Peerless Farms

FINAL PLAT
PROJECT NO. SF242

Letter of Intent

EXISTING DRAINAGE MAP
 PEERLESS FARMS
 11/13/2023

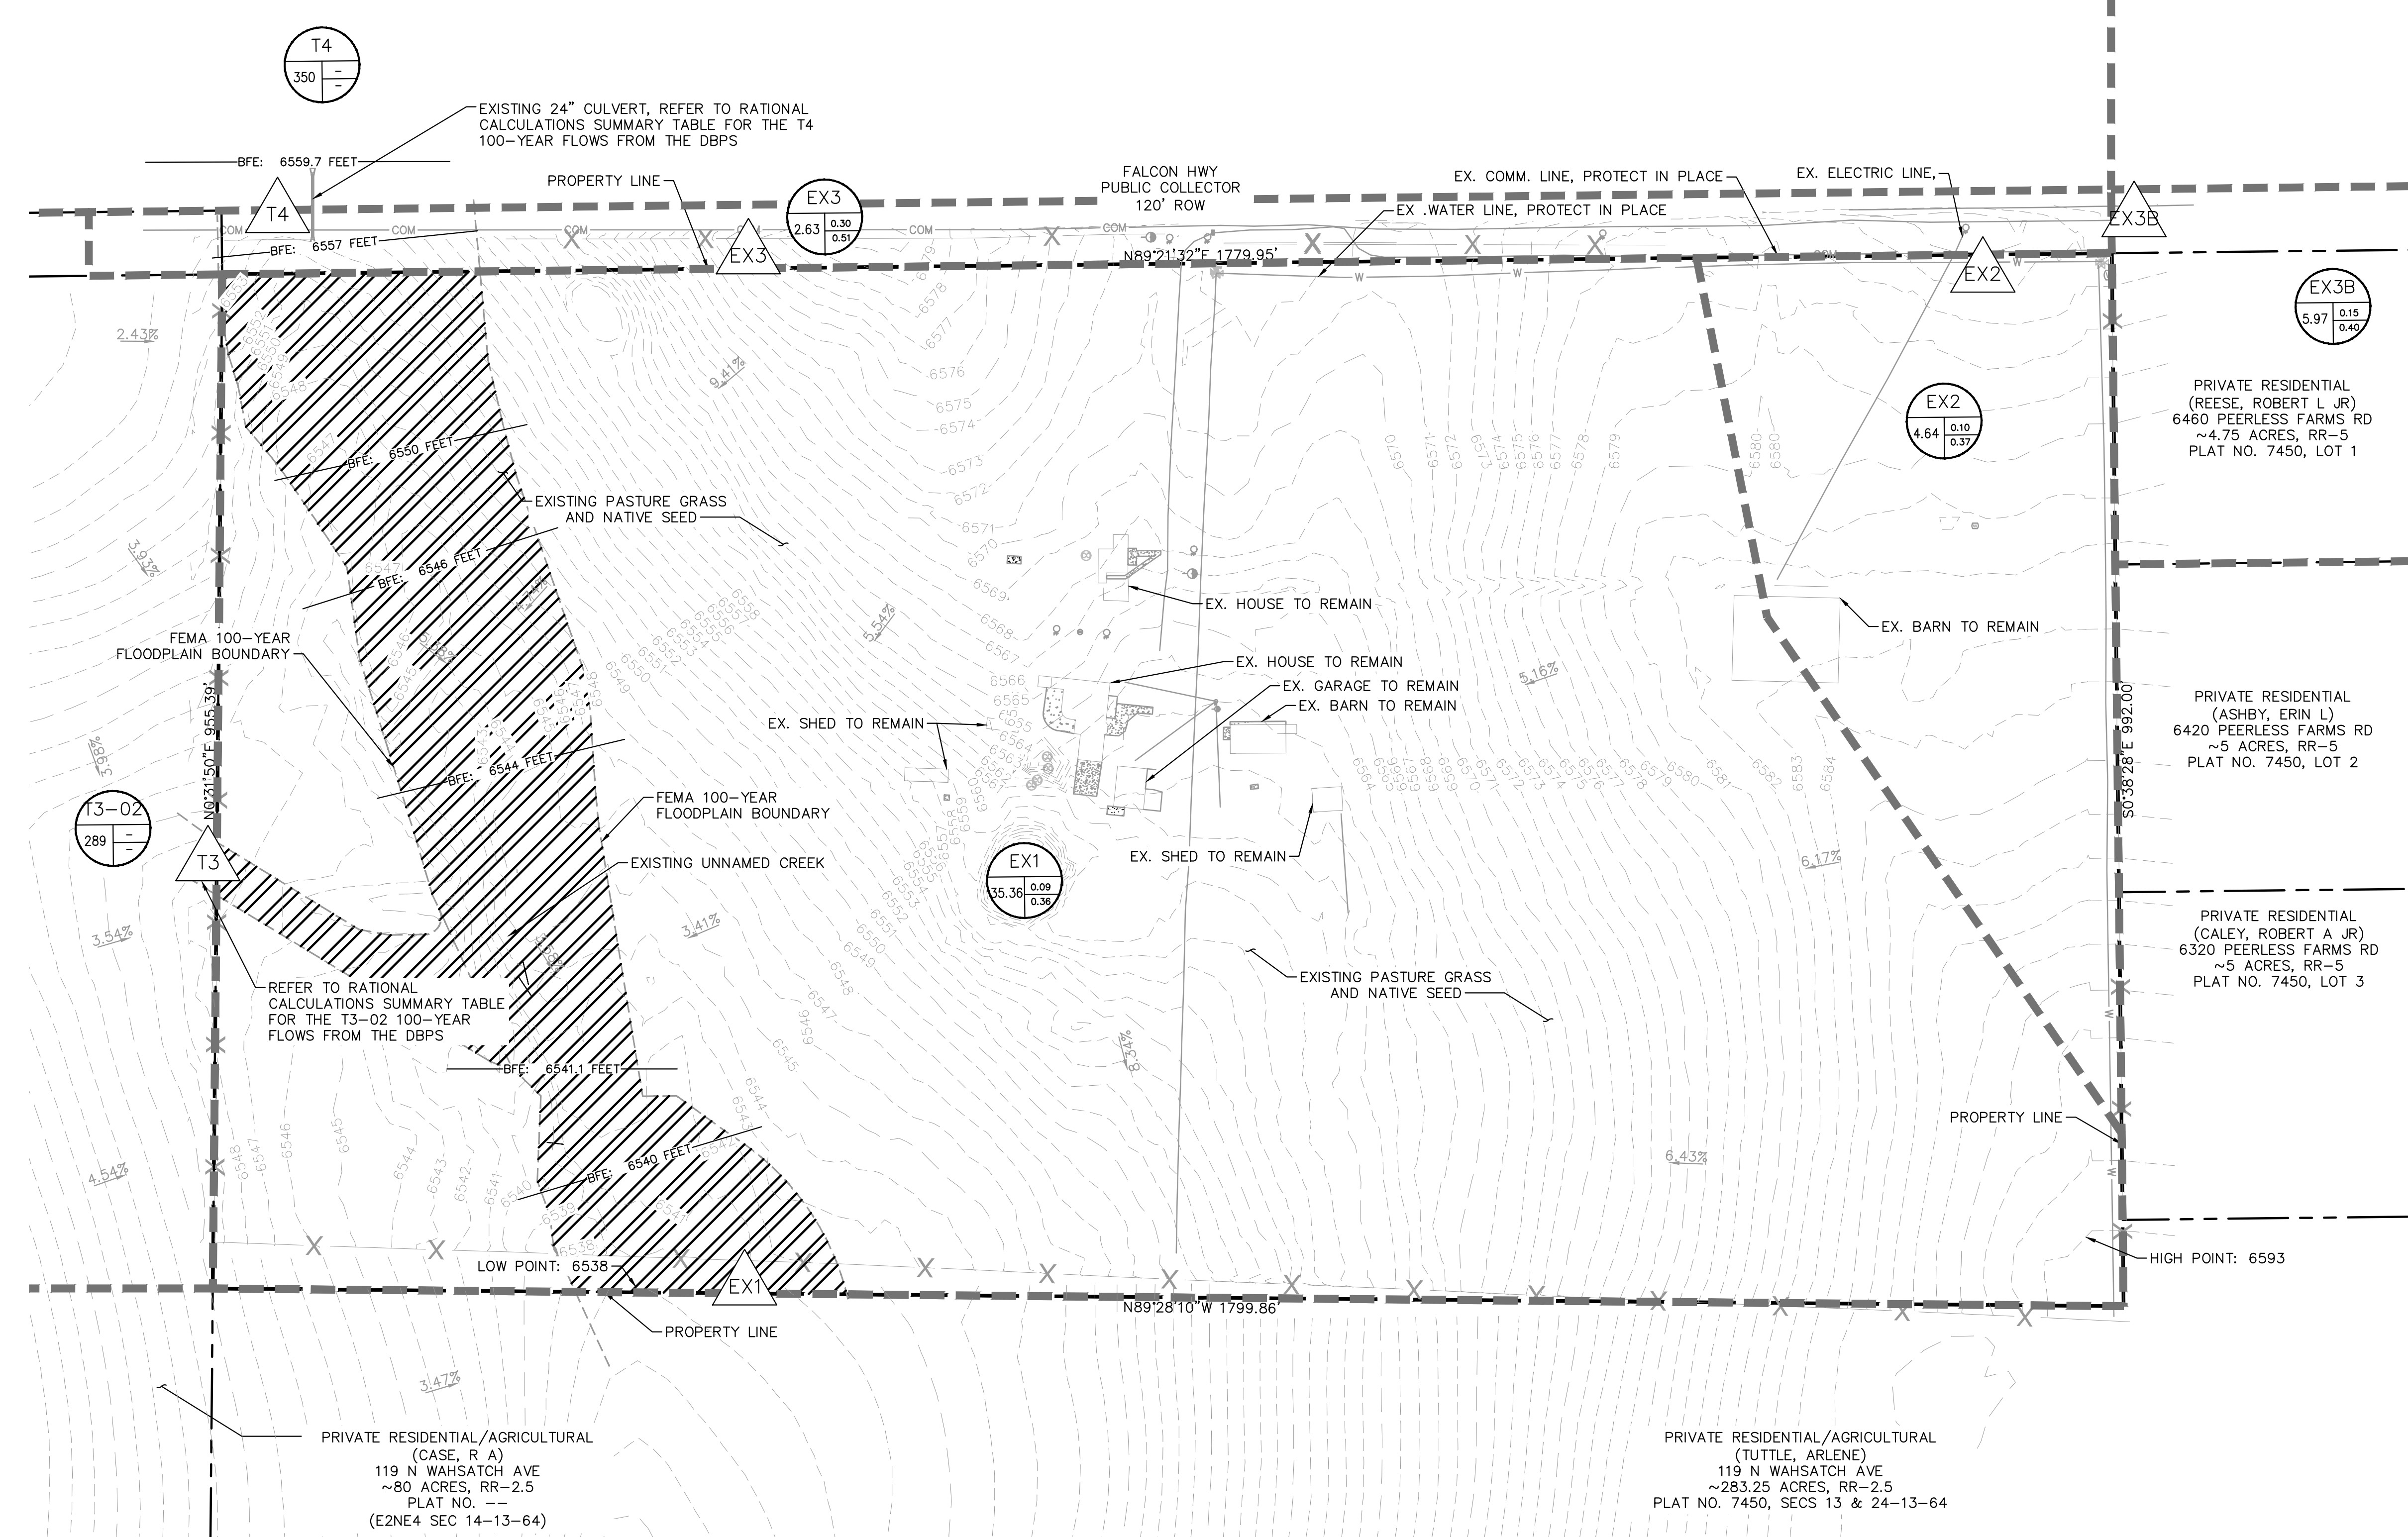
Unresolved from Submittal 1: The disturbance area associated with the roadway is greater than 1 ac and does require water quality. Based on the drainage report and PBMP form runoff reduction is the proposed method for satisfying permanent water quality requirements. Detention requirements are not based on a 1-acre disturbance and must be analyzed and determined if required no matter the disturbance area.
Added comment from Submittal 2: Adding a reference to the drainage report does not address that this LOI states there is less than 1 ac of disturbance which is not matching other reports/documents. Clarify.

SHEET No. FIG-11

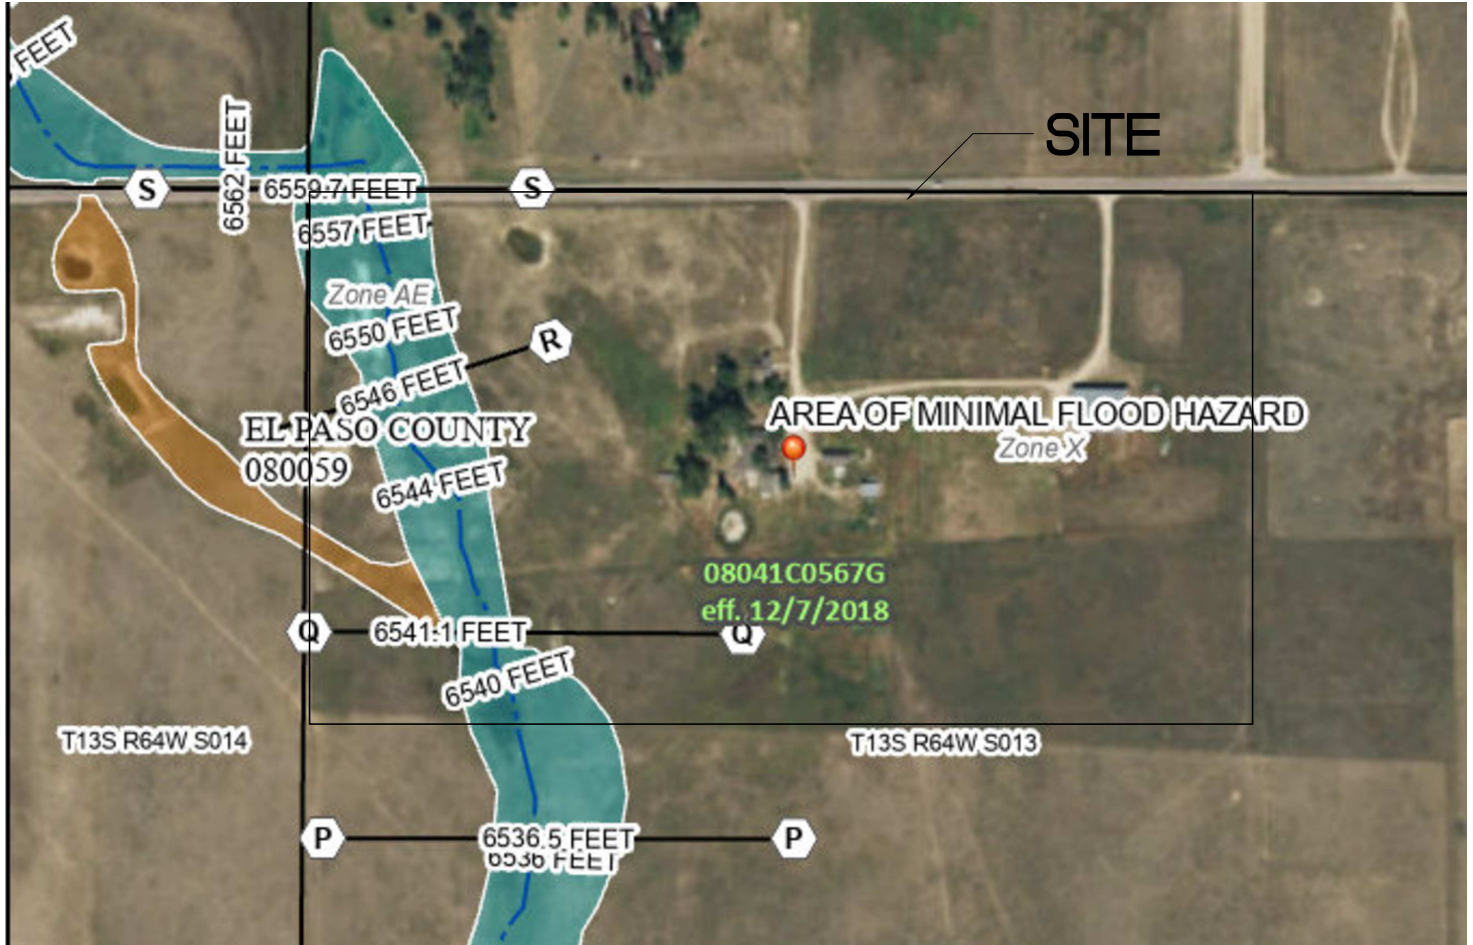
V1 Comment:
Floodplain and seasonal wetlands are hazards which result in no build areas.
